GKT 2431

**RE: FIRE DAMAGE AND STRUCTURAL REMEDIAL WORKS CARRIED OUT
AT 'KINGS HEAD', 3 WHITBURN STREET, BRIDGNORTH. WV16 4QN**

OBSERVATIONS: - (refer to marked up structure key plans ref GKT 2431-01 to 03 inclusive and structural calculations – sheets S01-S09 inclusive).

SPR STRUCTURE KEY PLAN
(1 of 3) - A3 SIZE.

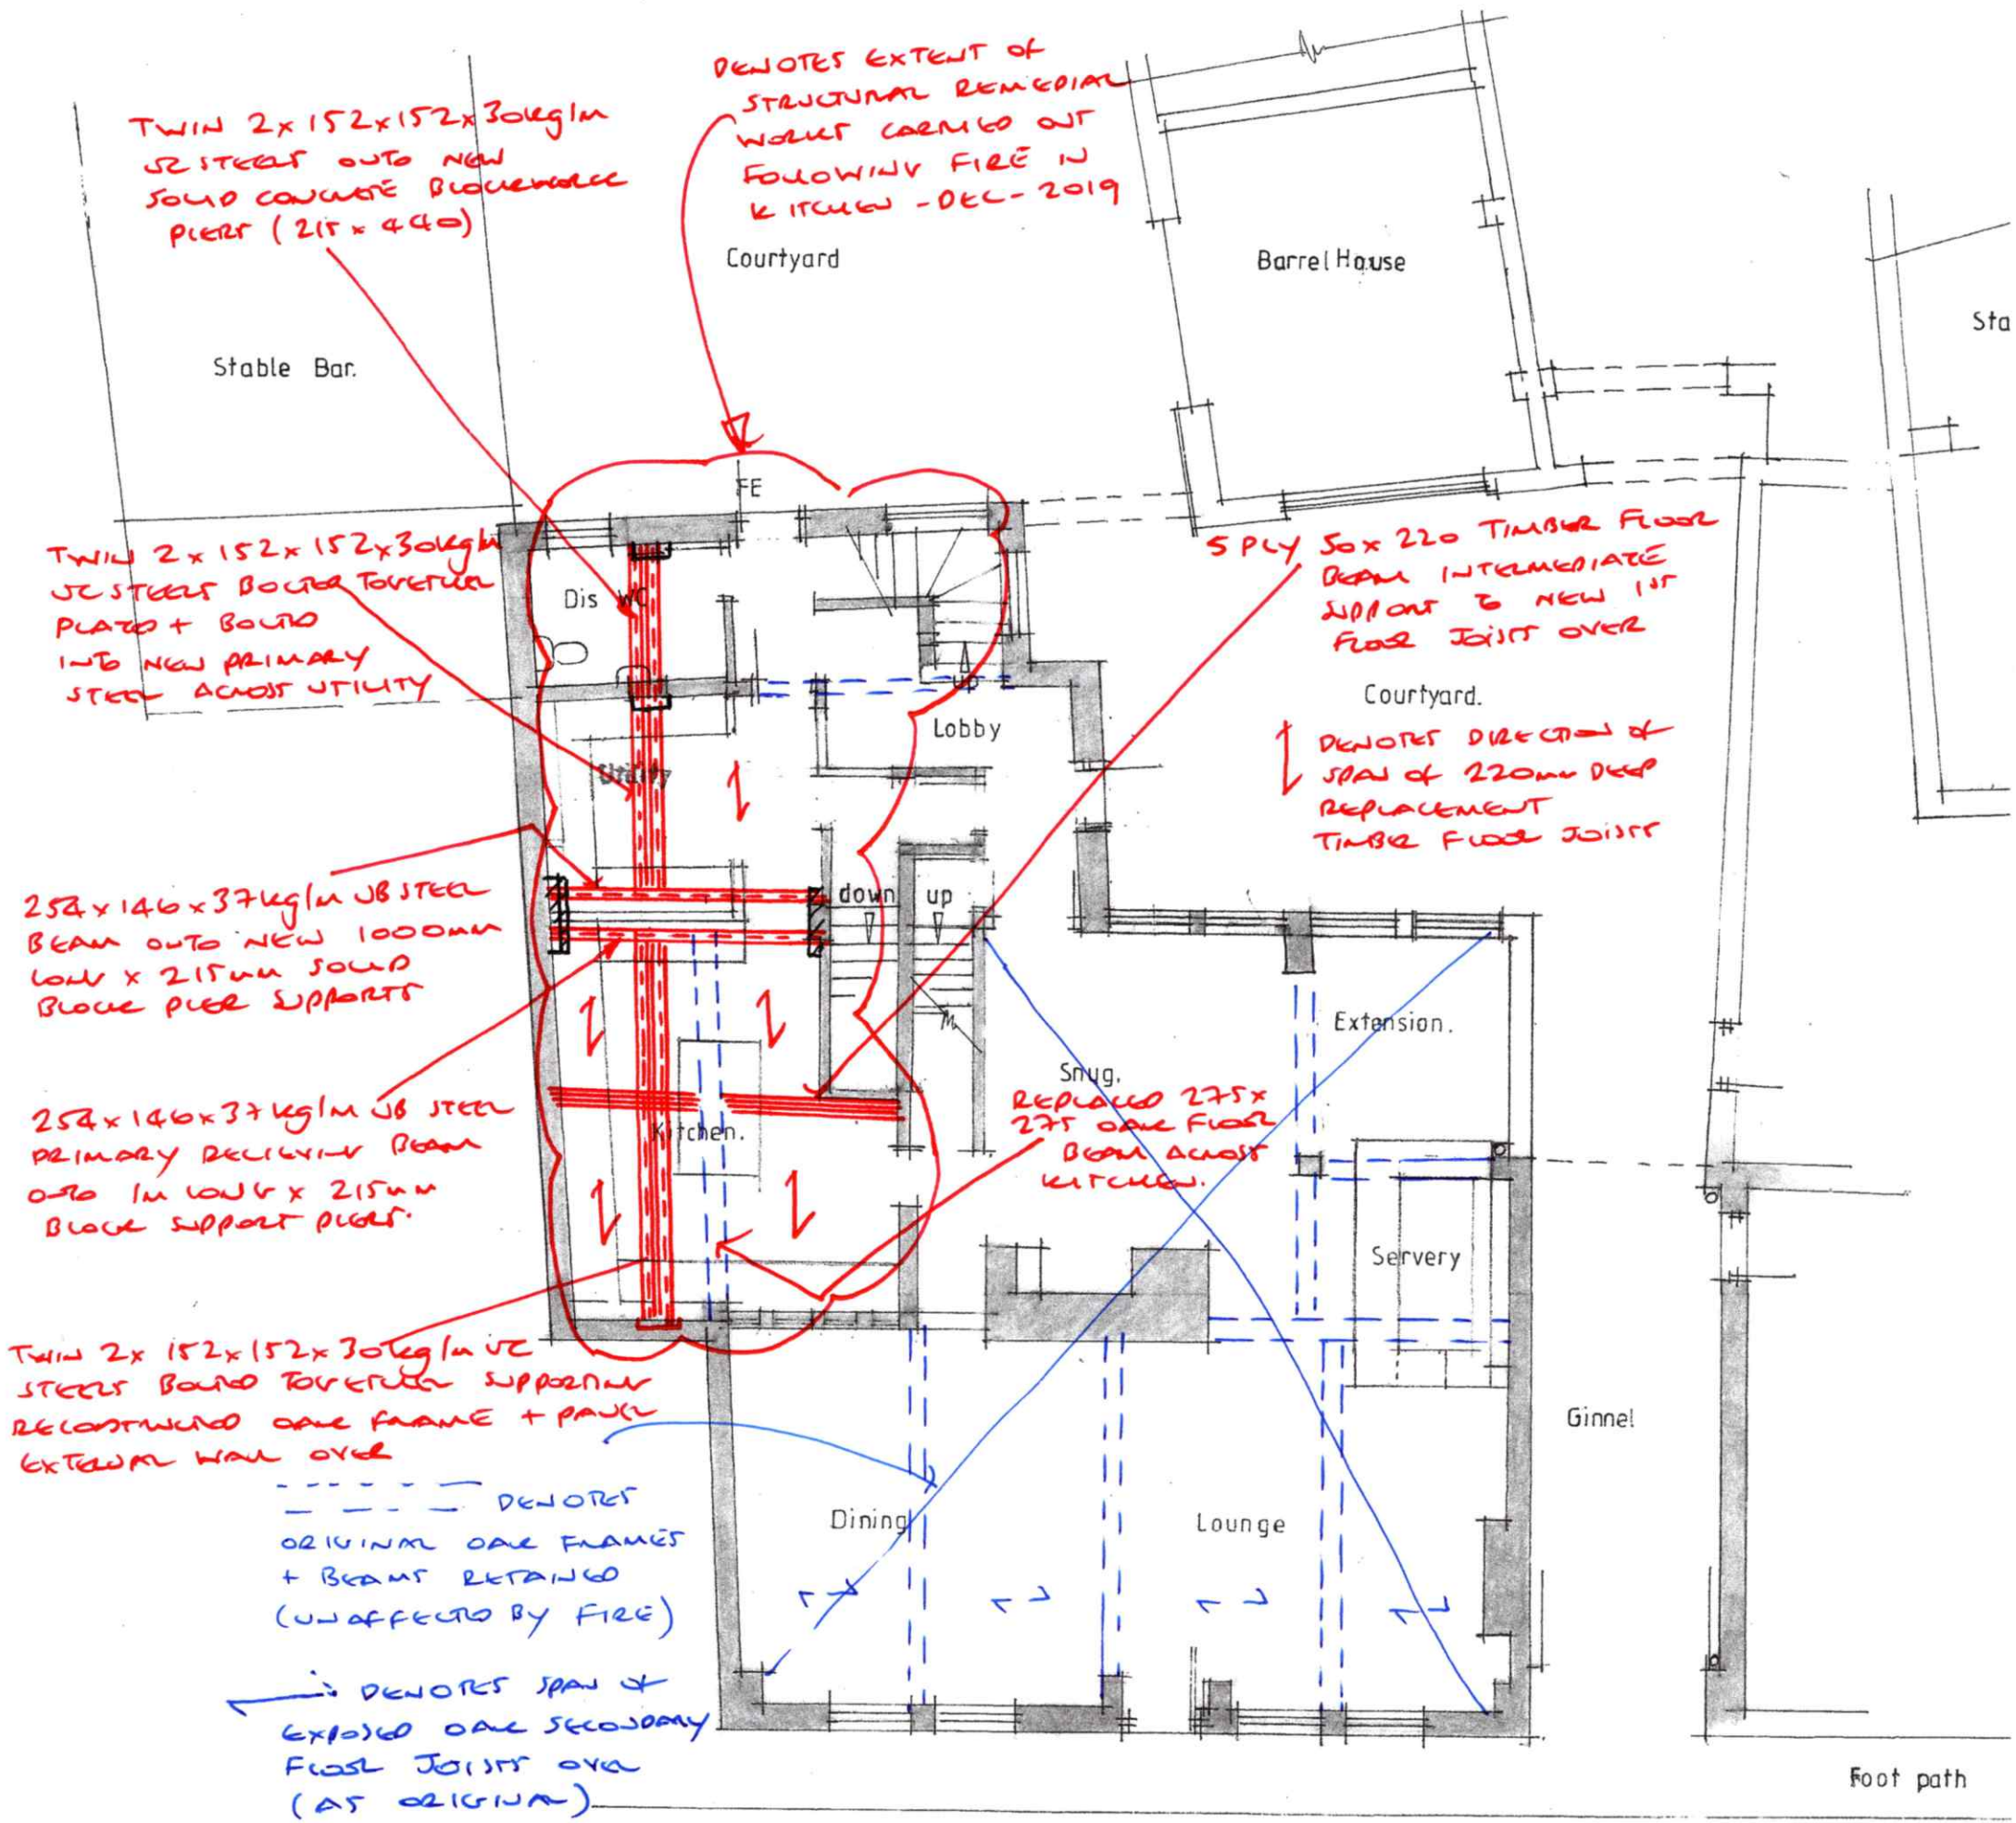
7. The reconstructed oak framed/masonry infilled side wall above the kitchen, utility and disabled w.c. is supported upon twin 152 x 152 x 30kg/m UC steels bolted together. These steels are in turn supported upon new solid masonry pier supports and two primary 254 x 146 x 37kg/m UB steel cross beams. The assessment by structural calculation confirms these steel supports are adequate with values for bending stresses and superimposed deflection values within permissible limits.

SUPERSTRUCTURE KEY PLAN
(2 of 3) - A3 SIZED.

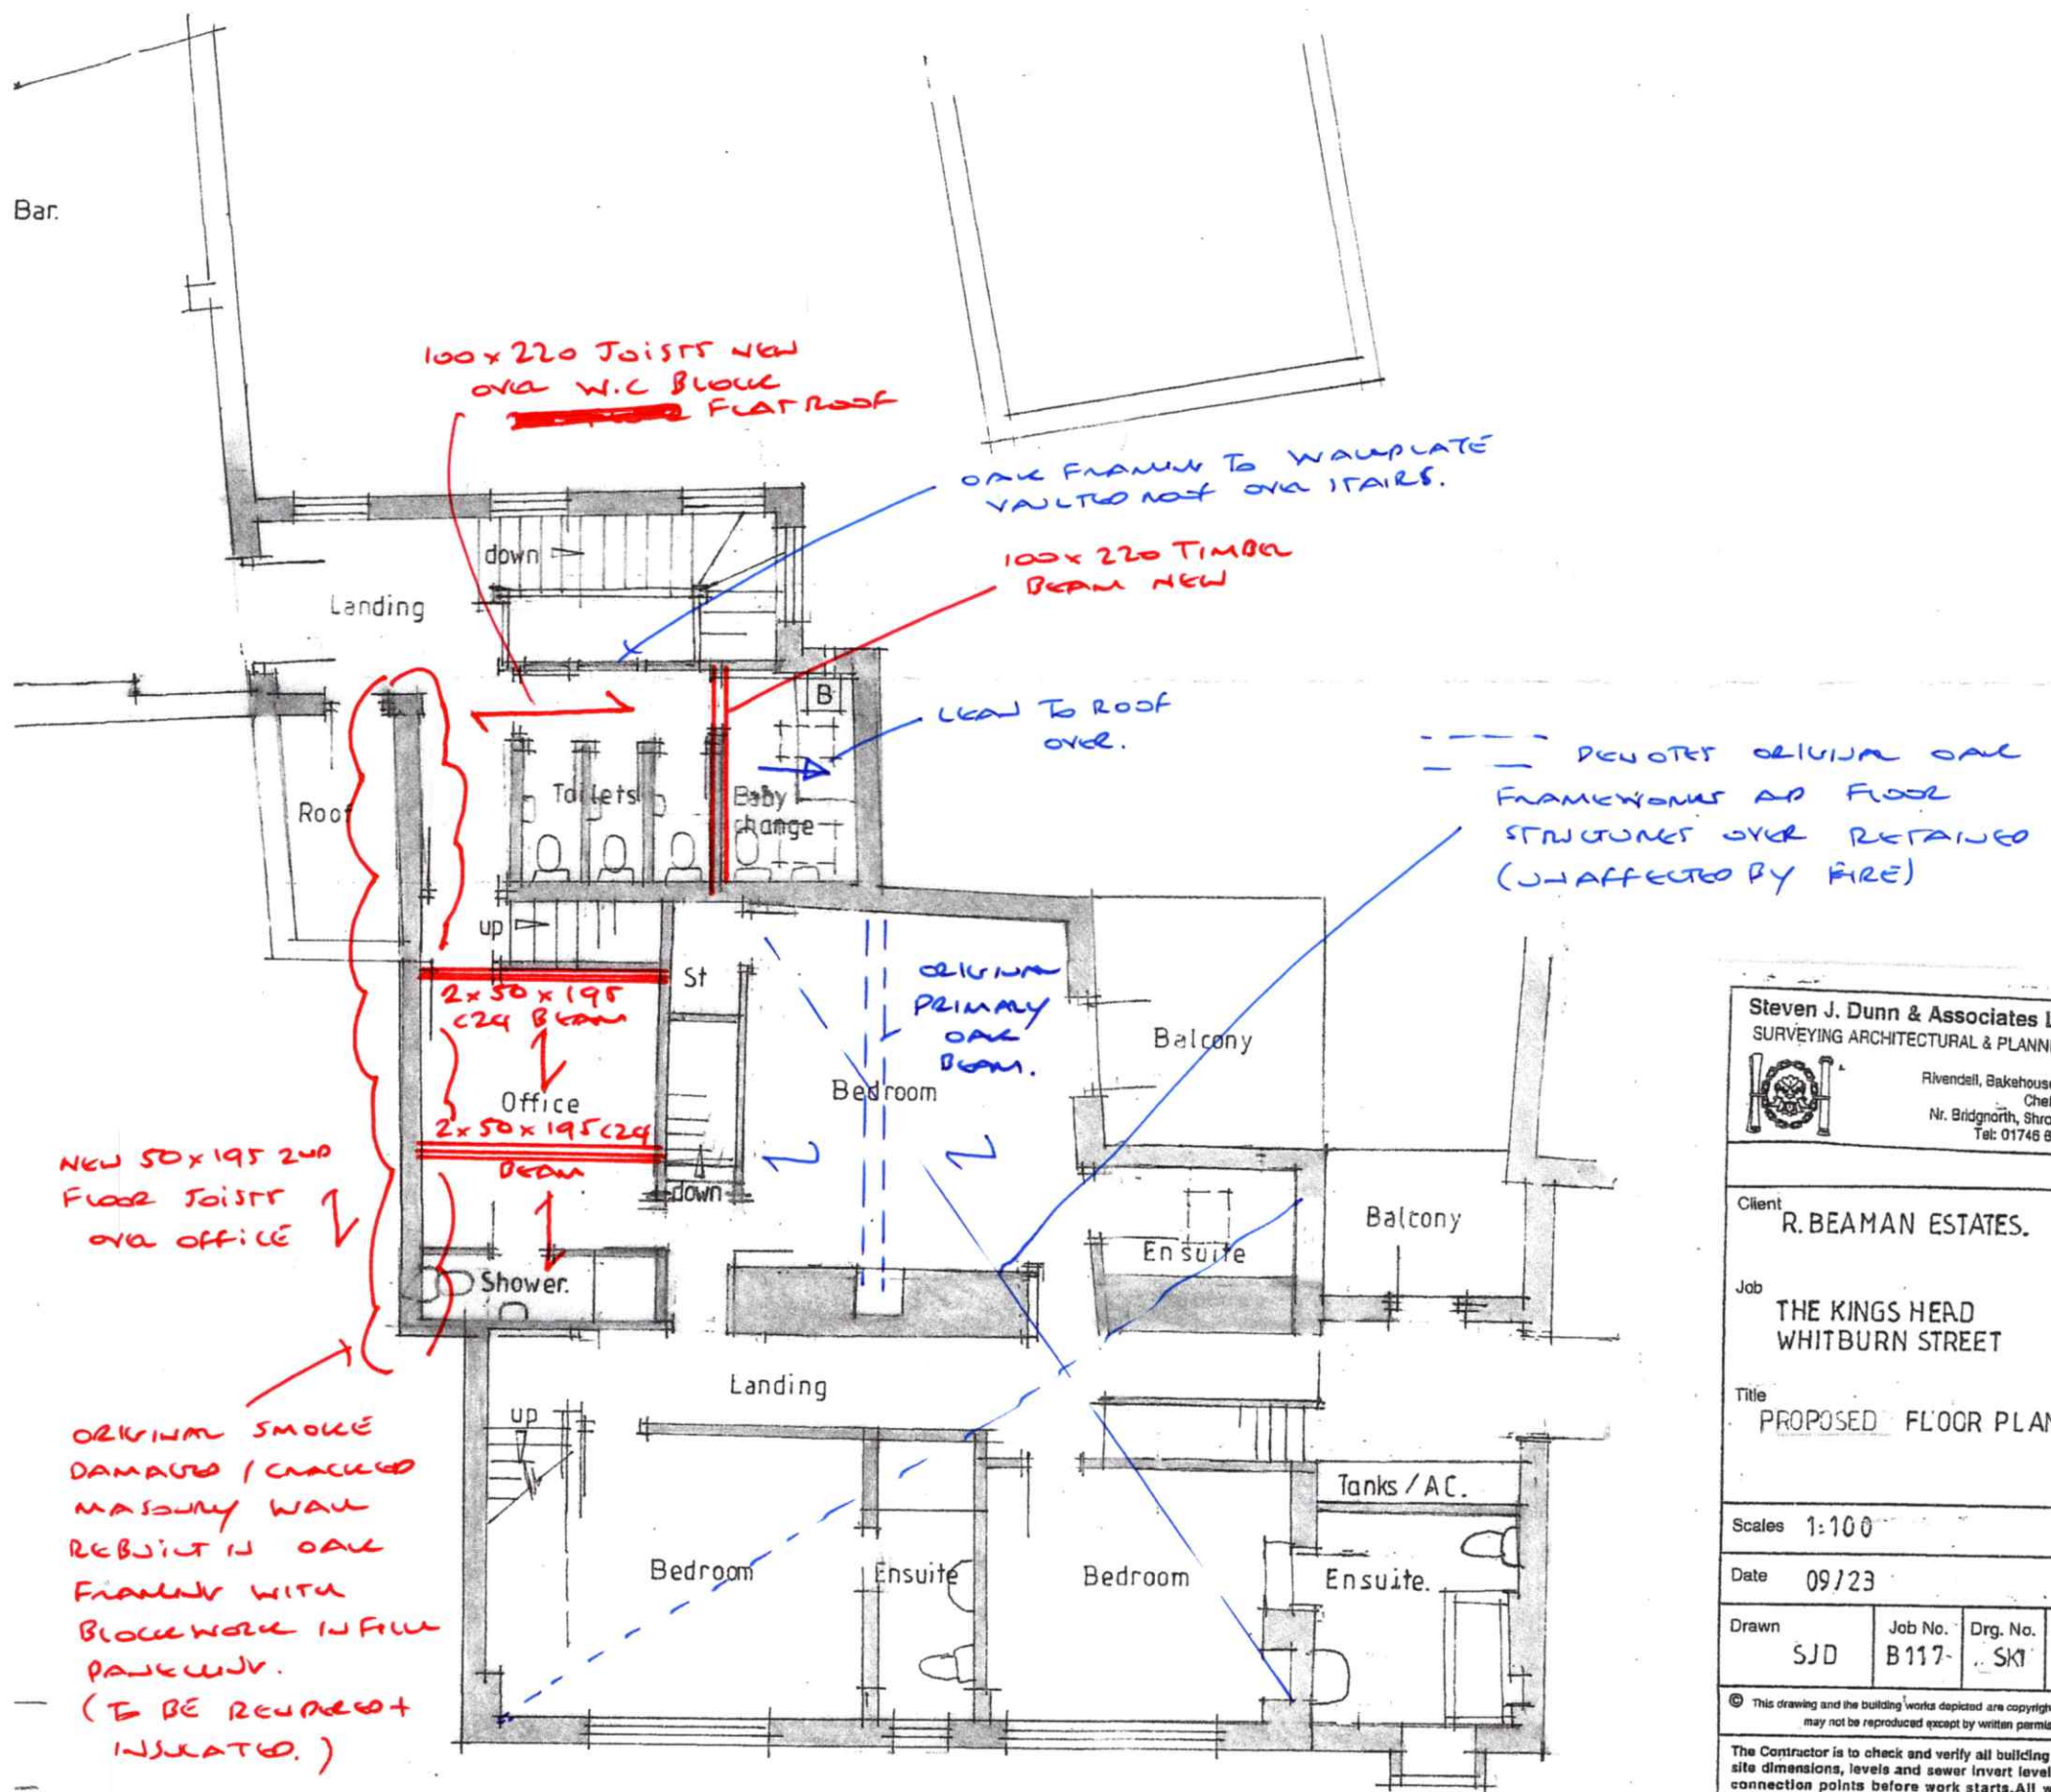
4. A replacement timber floor structure has been installed above the first-floor rear office with adequately sized timber joists supported by doubled trimmer joists acting as intermediate beams. These beams are overstressed and should be upgraded to tripled (3 ply joists) or strengthened with a 152 x 152 x 23kg/m UC Steel beam.

5. The flat roof and support beams have been re-constructed with adequately sized timber joists and support beams.
6. A replacement timber first floor structure has been installed above the kitchen and utility rooms with adequately sized timbers. A primary 275mm x 275mm deep exposed oak beam has been installed spanning across the kitchen and supporting multi-ply intermediate timber joist supports. The oak beam is adequately sized and installed to replicate the original construction.

The double joisted intermediate trimmer beams above the 1st floor office should be upgraded to triple 50 x 200 deep timbers or strengthened with a 152 x 152 x 23kg/m UC Steel beam.

SUPERSTRUCTURE KEY PLAN
(3 of 3) - A3 SIZED.

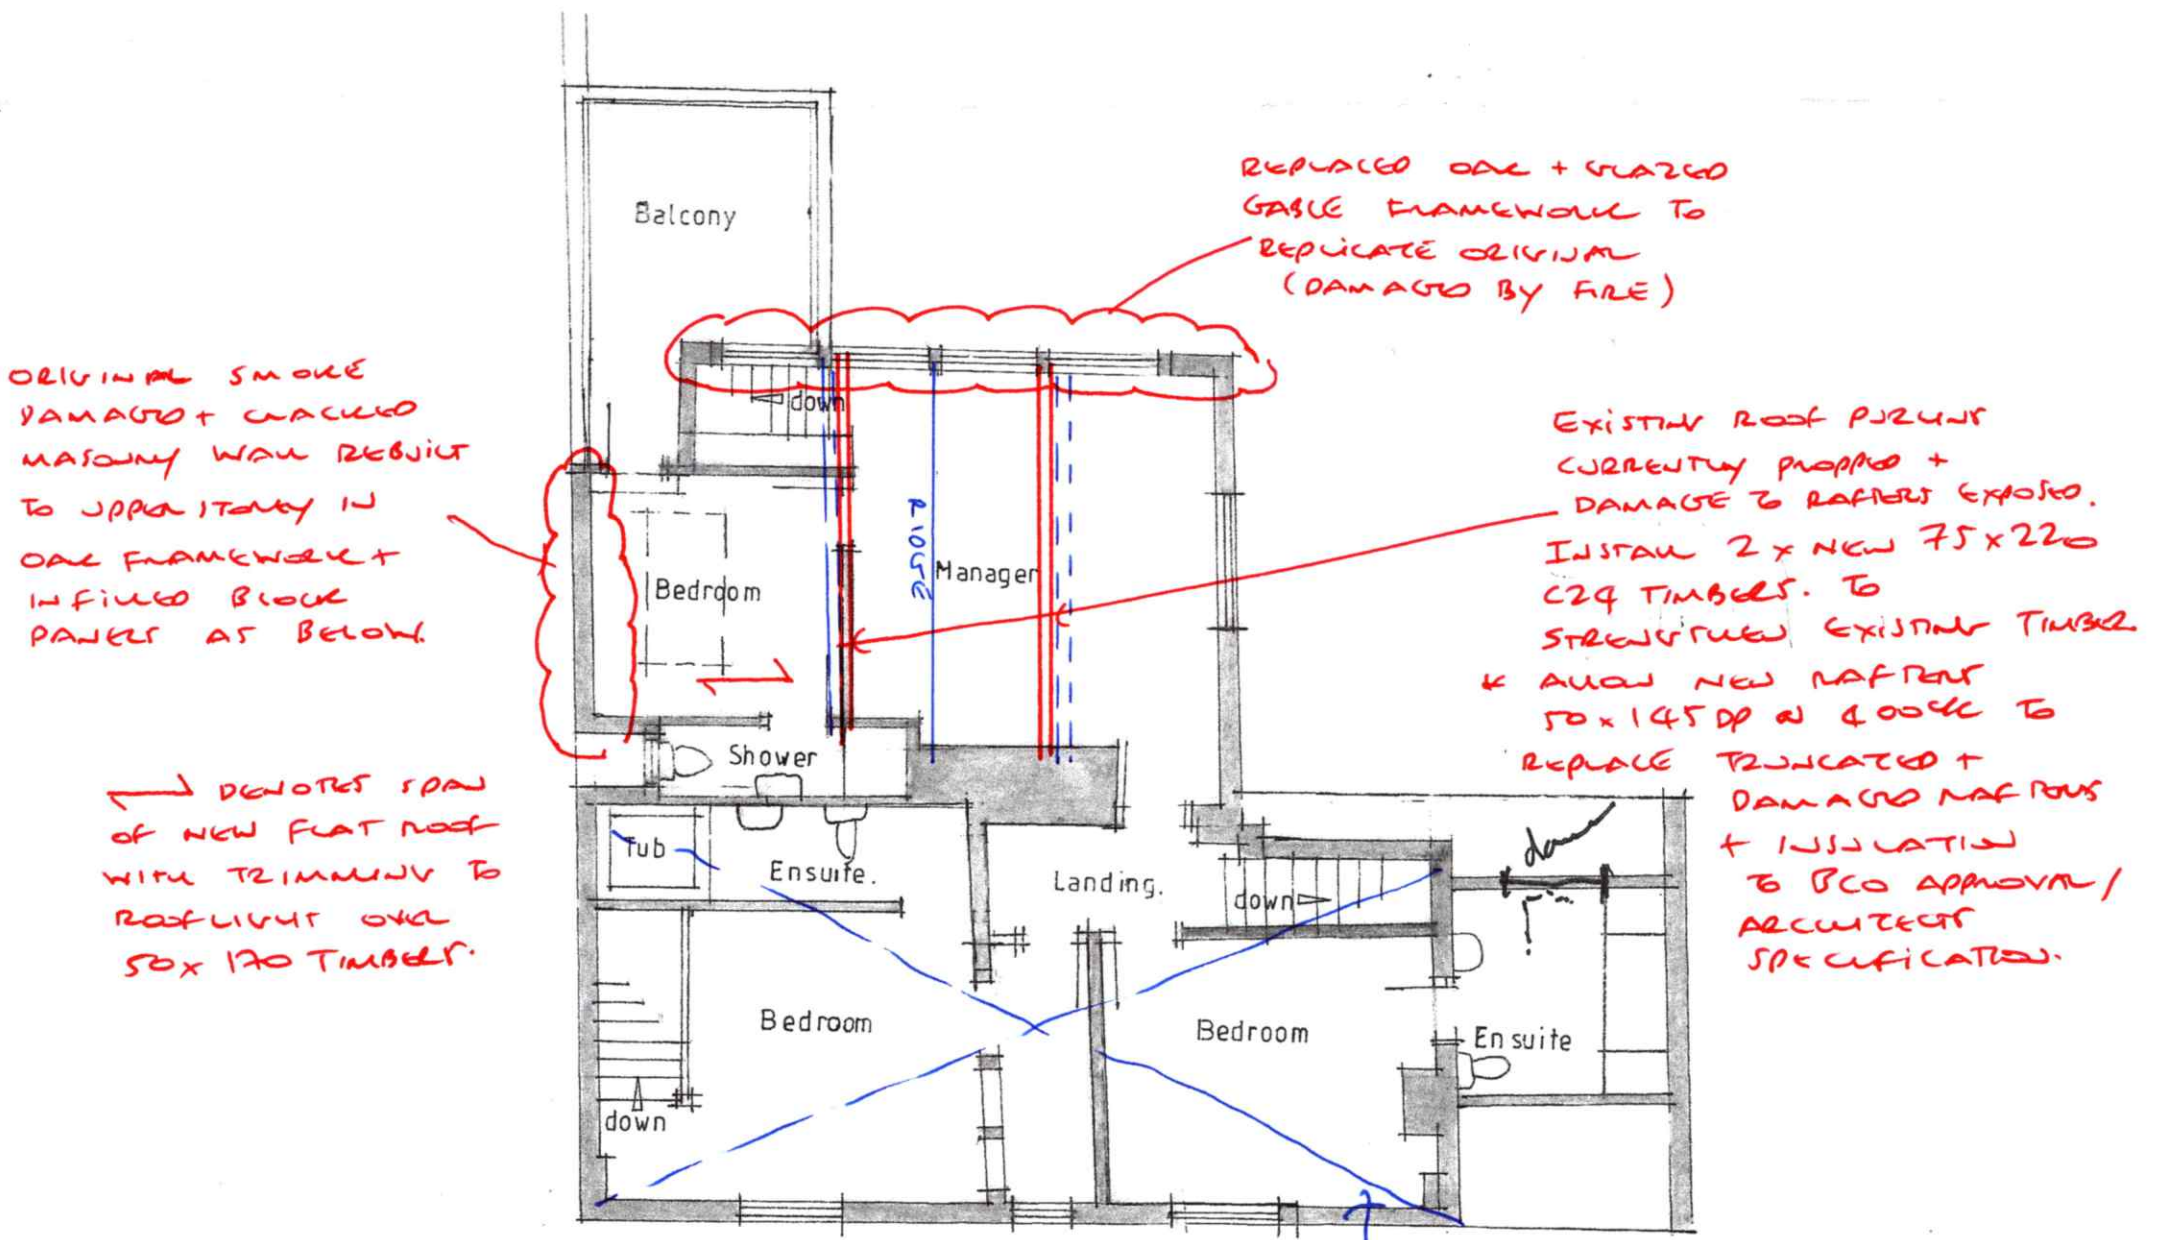
1. Part reconstruction of the rear gabled elevation (facing the courtyard) with new oak framing and glazing to the manager's office installed at second floor. This construction appears to be stable and has been re-built to replicate the original elevation.
N.B. The roof structure over the manager's office is currently supported by temporary propping. It will require remedial strengthening with the introduction of 2 x twin 150mm wide x 220 deep timber purlins in order to restore its integrity.

2. The left-hand side wall (rear second floor bedroom) and flat roof over have been replaced and are structurally acceptable.
3. The left-hand side external wall at first floor level (adjacent to w.c. block, and rear first floor office area) have been reconstructed with oak framing and masonry infilled panels. We understand this wall is to be rendered to its exterior and insulated internally to replicate the original wall.

The main roof structure above the Manager's office at 2nd floor will also require remedial strengthening as recommended and outlined in the marked-up structure plan (3 of 3) in order to restore its structural integrity.
